CITY OF ALBUQUERQUE

June 17, 2021

Re: Standard Diner/Range Café Patio Expansion
320 Central Ave SE
30-Day Temporary Certificate of Occupancy
Transportation Development Final Inspection
Engineer's/Architect's Stamp dated 9-15-20 (K14D055)
Certification dated 6-14-21

A1 TRAFFIC CIRCULATION PLAN

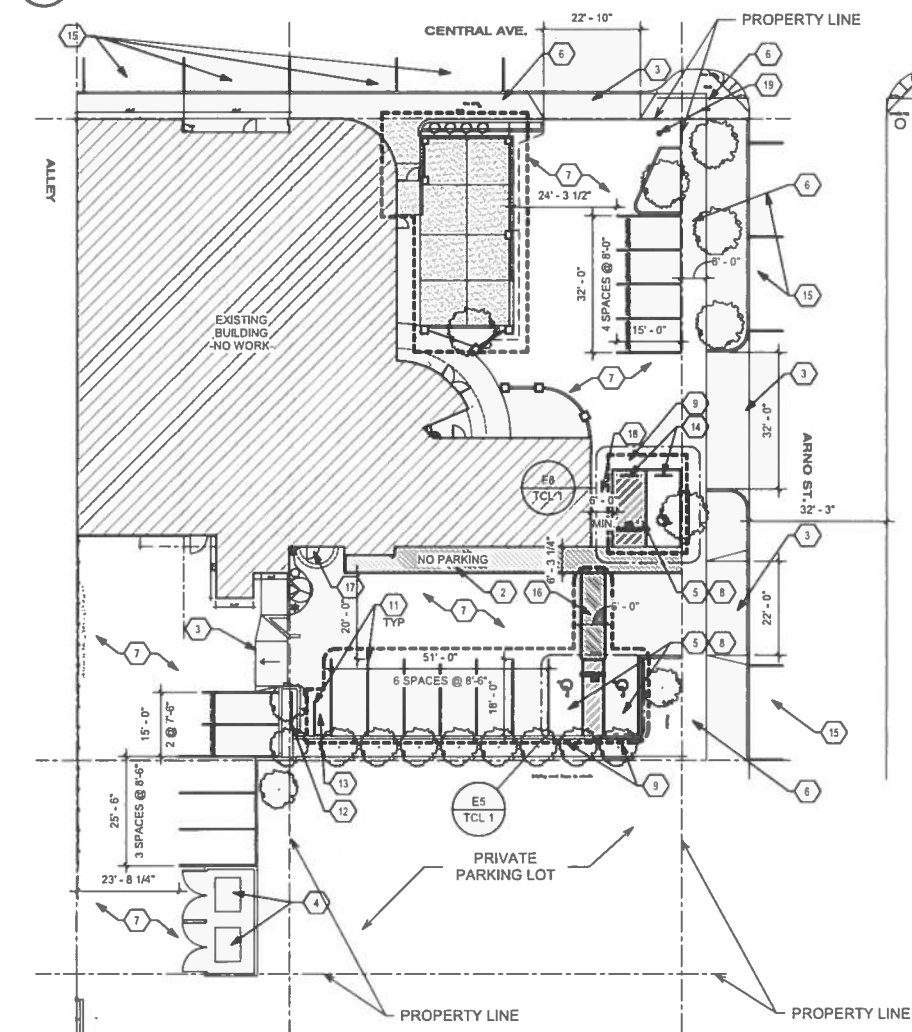
- The ADA accessible aisles will need to have the words "NO PARKING"
- Bicycle Parking on dirt/ground: What happens when it rains and the parking surface turns muddy. What type of solution after the rain will be provide with this concern.
- ADA stall: it appears post support need to be flushed on asphalt surfaces. Please verify that there isn't any issue.
- Provide a clear pathway from the stalls to the front of the building. At present time, there is no clear pathway from accessible aisle to building entrance. Please provide some type of delineation to define this pathway.
